## OFFICIAL NOTICE OF DECISION

CITY OF ALBUQUERQUE  
PLANNING DEPARTMENT  
DEVELOPMENT REVIEW BOARD

**5. Project # 1003523**  
05DRB-01369 Major-Preliminary Plat Approval  
05DRB-01368 Major-SiteDev Plan Subd  
05DRB-01370 Minor-Temp Defer SDWK

RIO GRANDE ENGINEERING agent(s) for GHP, LLC request(s) the above action(s) for LOT 30, 31, 32 and 33, LANDS OF ATRISCO GRANT, UNIT 3, (to be known as **PRIMA ENTRADA SUBDIVISION**) zoned SU-2 FOR R-LT, located on 98<sup>TH</sup> ST NW, between ENDEE RD NW and I-25 NW containing approximately 17 acre(s). [REF:04EPC-01003, 04EPC-01352, 04EPC-01489] [*Deferred from 9/28/05 & 11/2/05 & 11/9/05 & 11/23/05*](J-8)

ACS MONUMENT  
6-K9  
Z=5247.434  
Y=144931.98  
X=352217.80  
NAD 1987, NAVD 1929  
G/G=0.9987416  
DELTA/PLA=00°17'02"  
CENTRAL ZONE

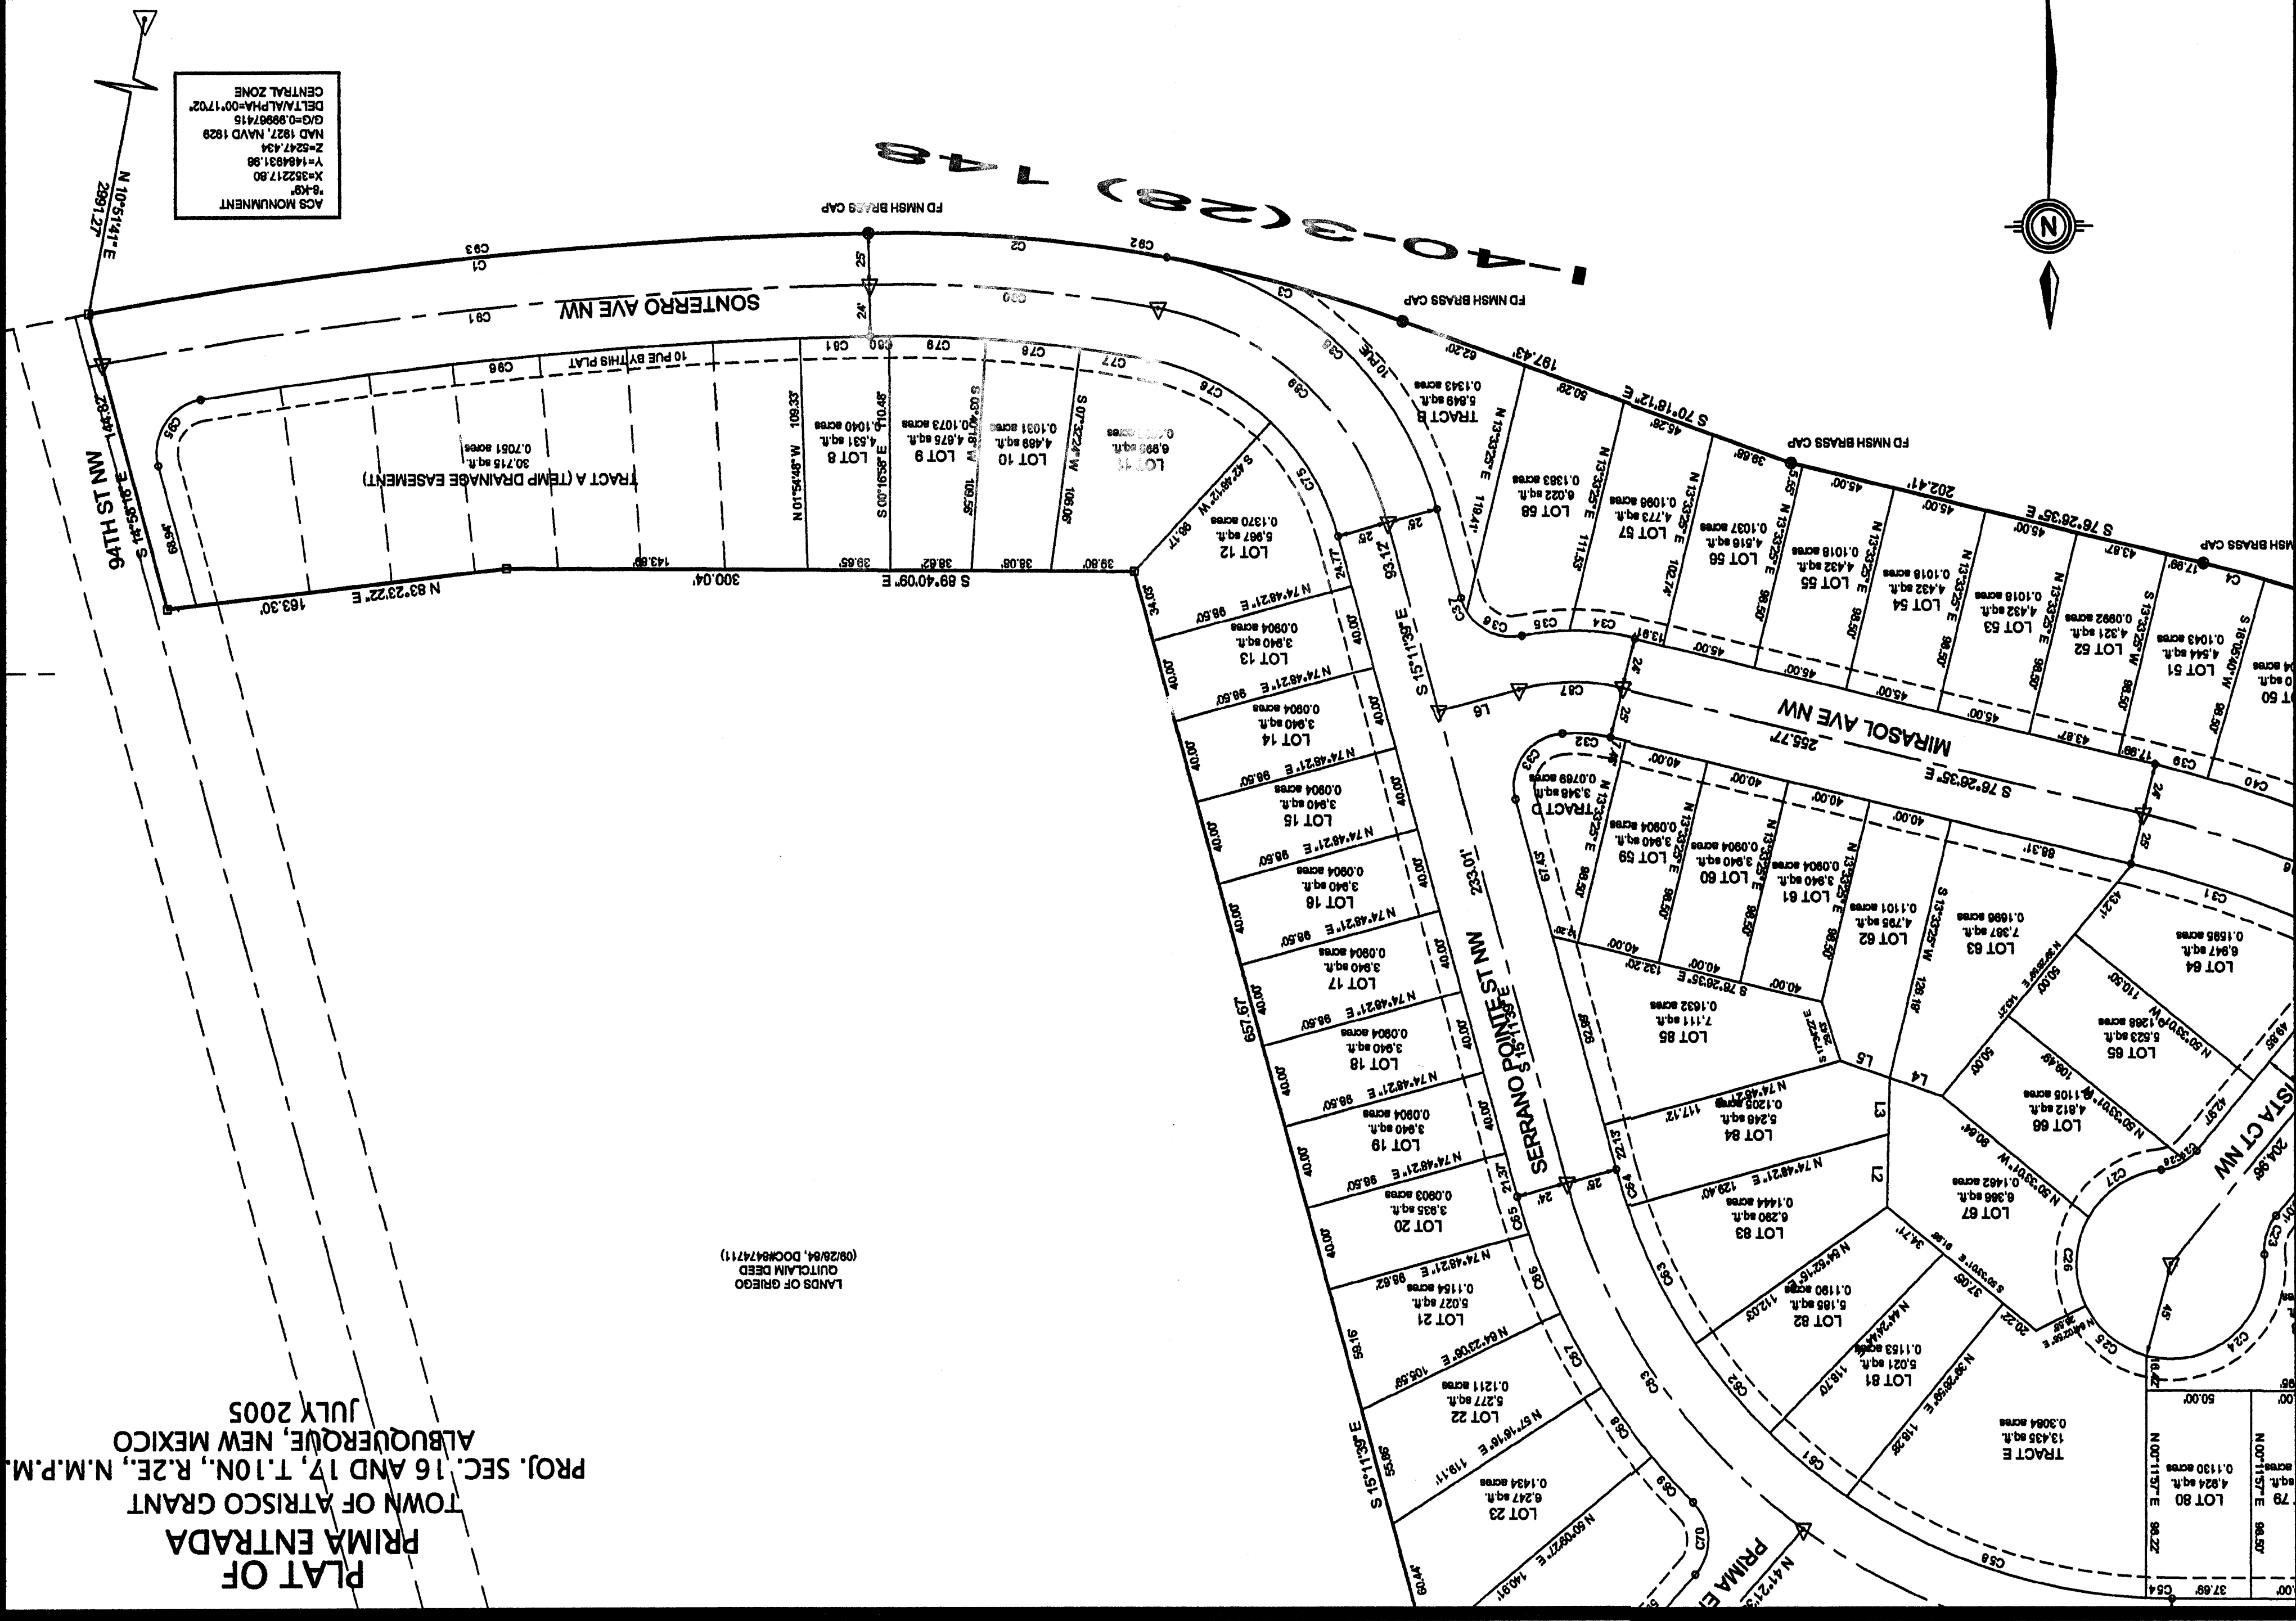
P-1 lot designations.

Entrada Vista Court shall become a private access easement. Maintenance and Beneficiary Statement shall be placed on the plat.

The zoning designation shall be on the final plat.
